Phone: 0300 123 6780
Email: developeras@lancashire.gov.uk
Your ref: 3/2025/0681
Our ref: 3/2025/0681/HDC/KW
Date: 30 January 2026

Location: 14 Lancaster Drive Clitheroe BB7 2PD
Proposal: Proposed partial demolition of existing dwelling, and rebuild with extensions, alterations and roof lift with rear dormer extensions.
Grid Ref: 373257 441471

Introduction

**Proposed Ground Floor Plan**  
 1 : 50

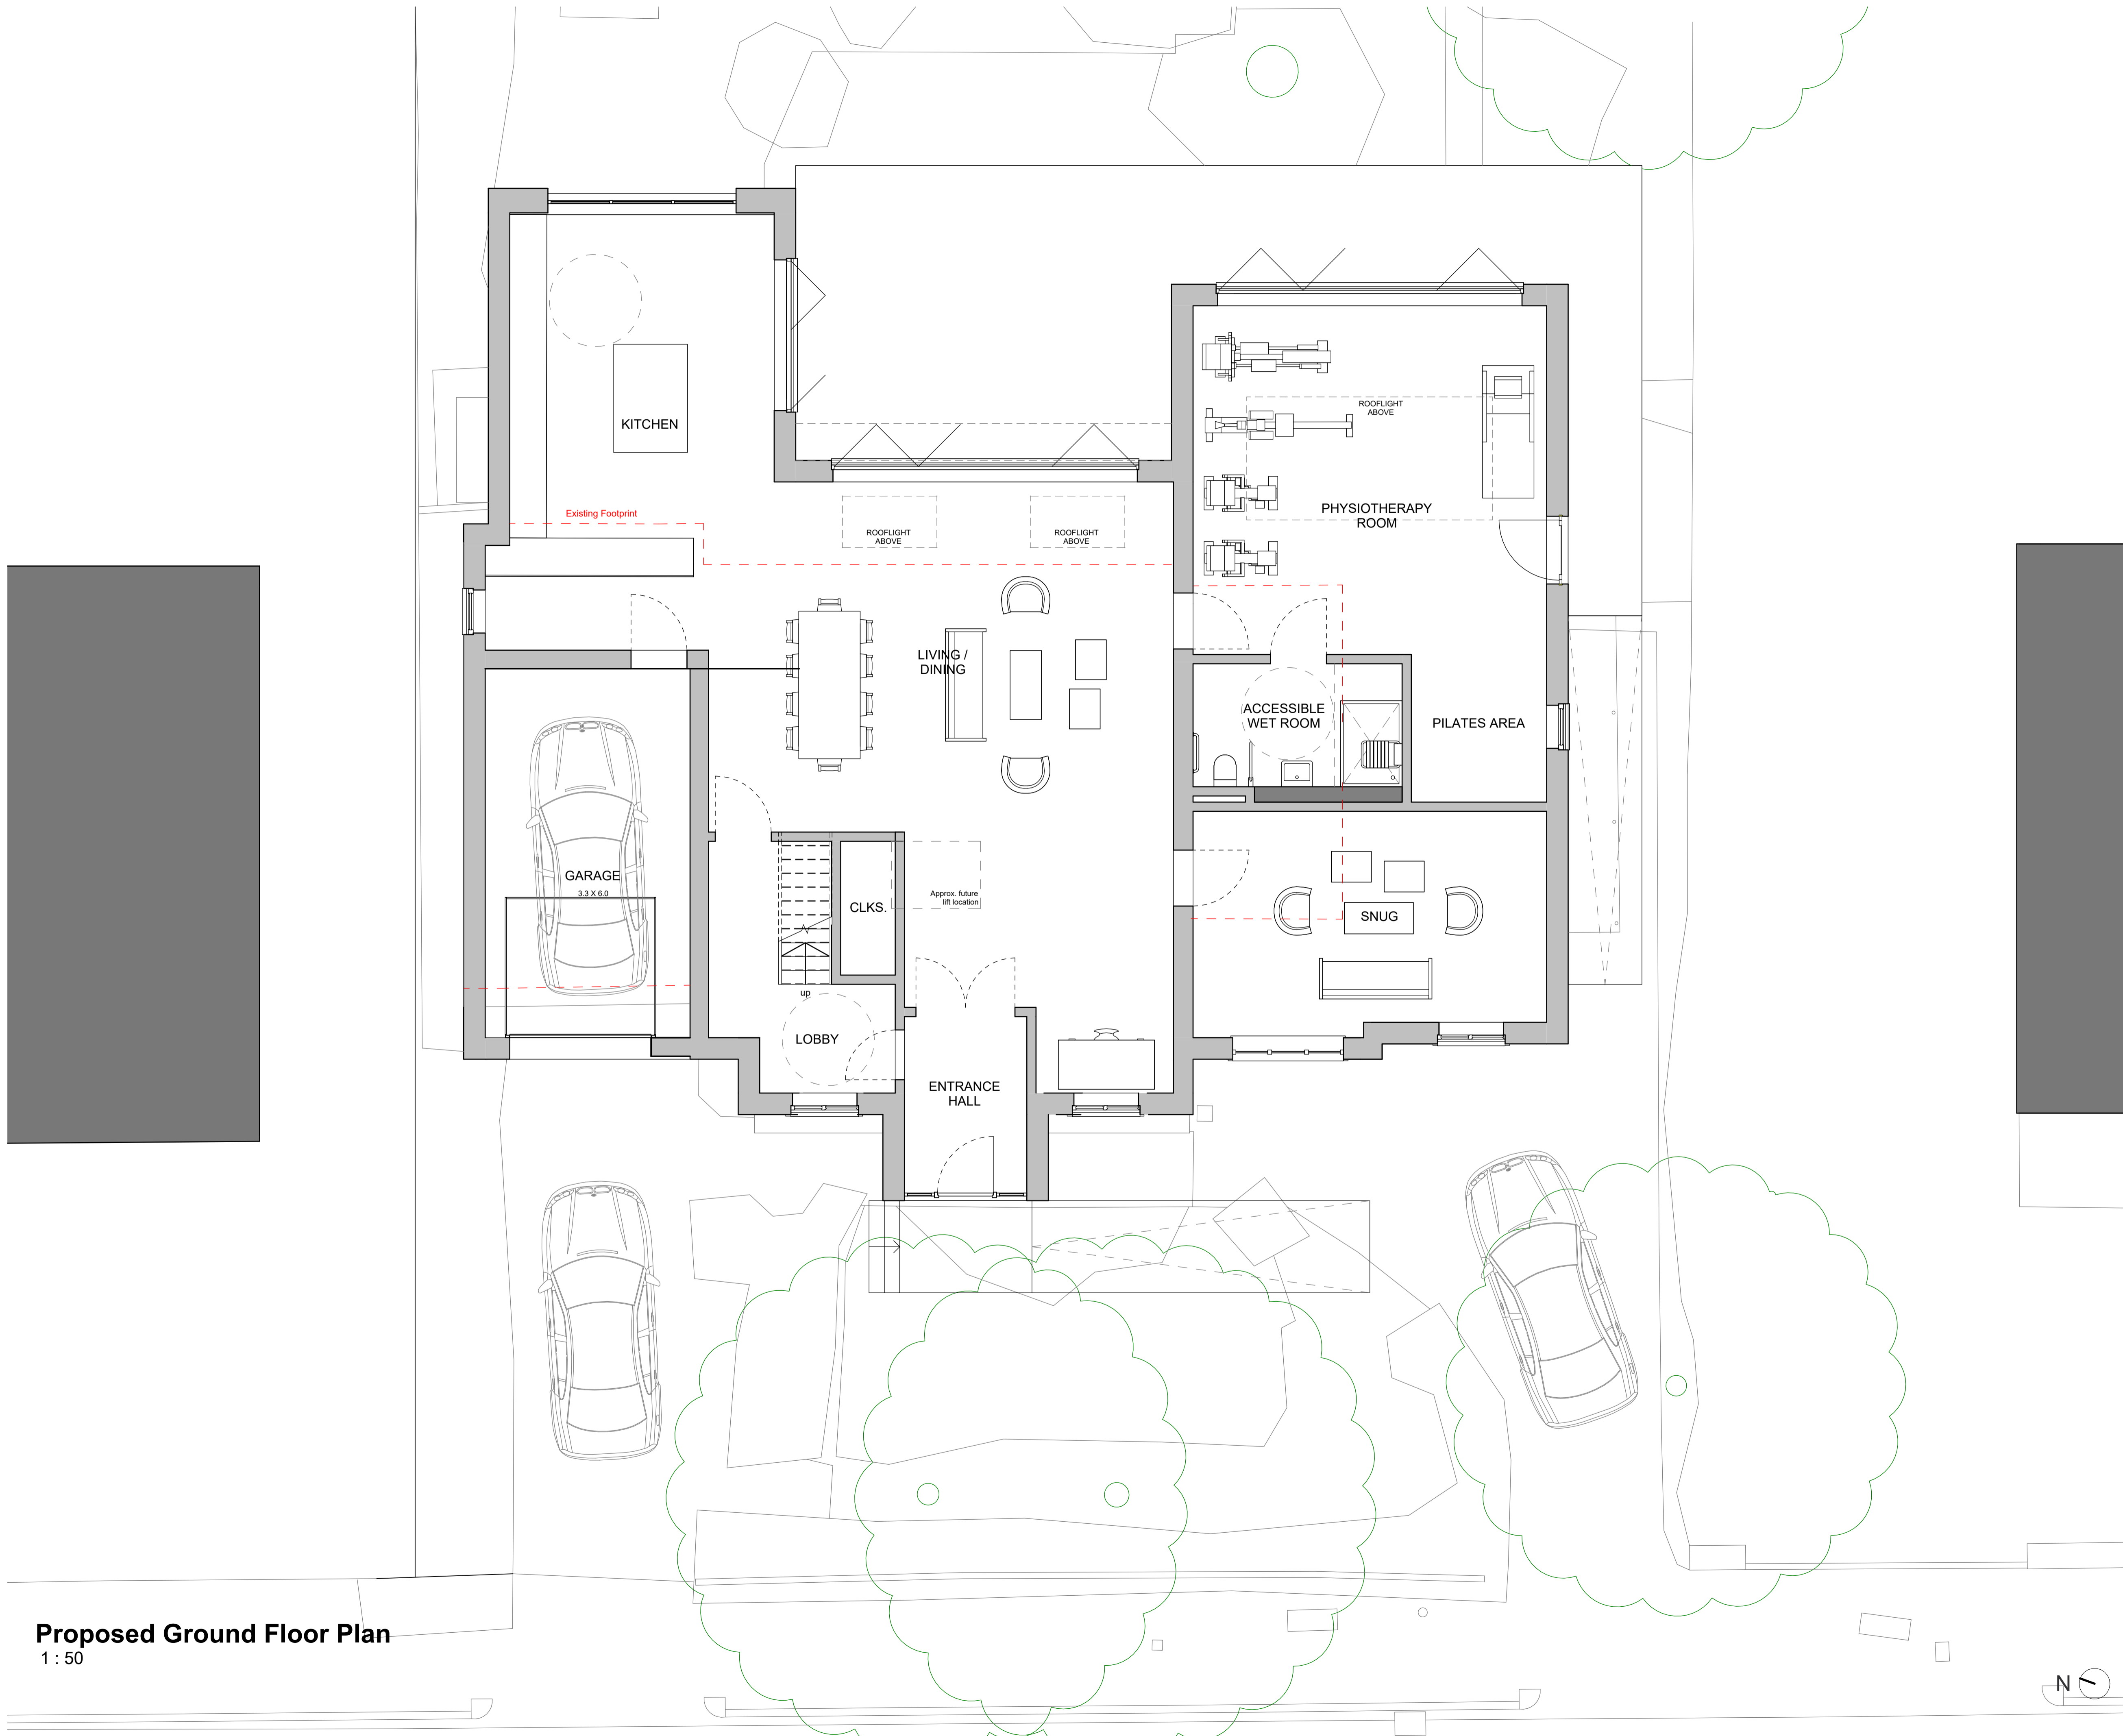
The LHA have reviewed PGB drawing number 0104 revision 2 titled Proposed Ground Floor Plan and are aware that the dwelling complies with the LHAs parking standards as defined in the Joint Lancashire Structure Plan. Therefore, the LHA have no objection to the proposal.

The recommended minimum internal dimensions for a single garage size is 6m in length and 3m wide. The recommended distance of 6m is based on the length of a large family

car (Ford Mondeo Estate 4.58m long), clearance at the rear of the car (200mm), overhang of the garage door (600mm) and room to stand in front of the car and open/close the garage door (600mm). The proposed garage meets the recommend minimum internal dimensions and as such can be counted as a parking space.

1. The development hereby permitted shall not be occupied or brought into use until the car parking and turning areas shown on the approved plan(s) have been provided in full and are available for use. The car parking and turning areas shall thereafter be kept available for the parking and manoeuvring of vehicles at all times.
Reason: To ensure the provision of adequate car parking on site and in the interests of highway safety.

3. The garage hereby approved shall be kept available for the parking of vehicles ancillary to the enjoyment of the household and shall not be used for any use that would preclude the ability of their use for the parking of private motor vehicles, whether or not permitted by the provisions of the Town and Country Planning (General Permitted Development) Order 2015 or any order amending or revoking and re-enacting that order.
Reason: To ensure that adequate parking provision is retained on site.
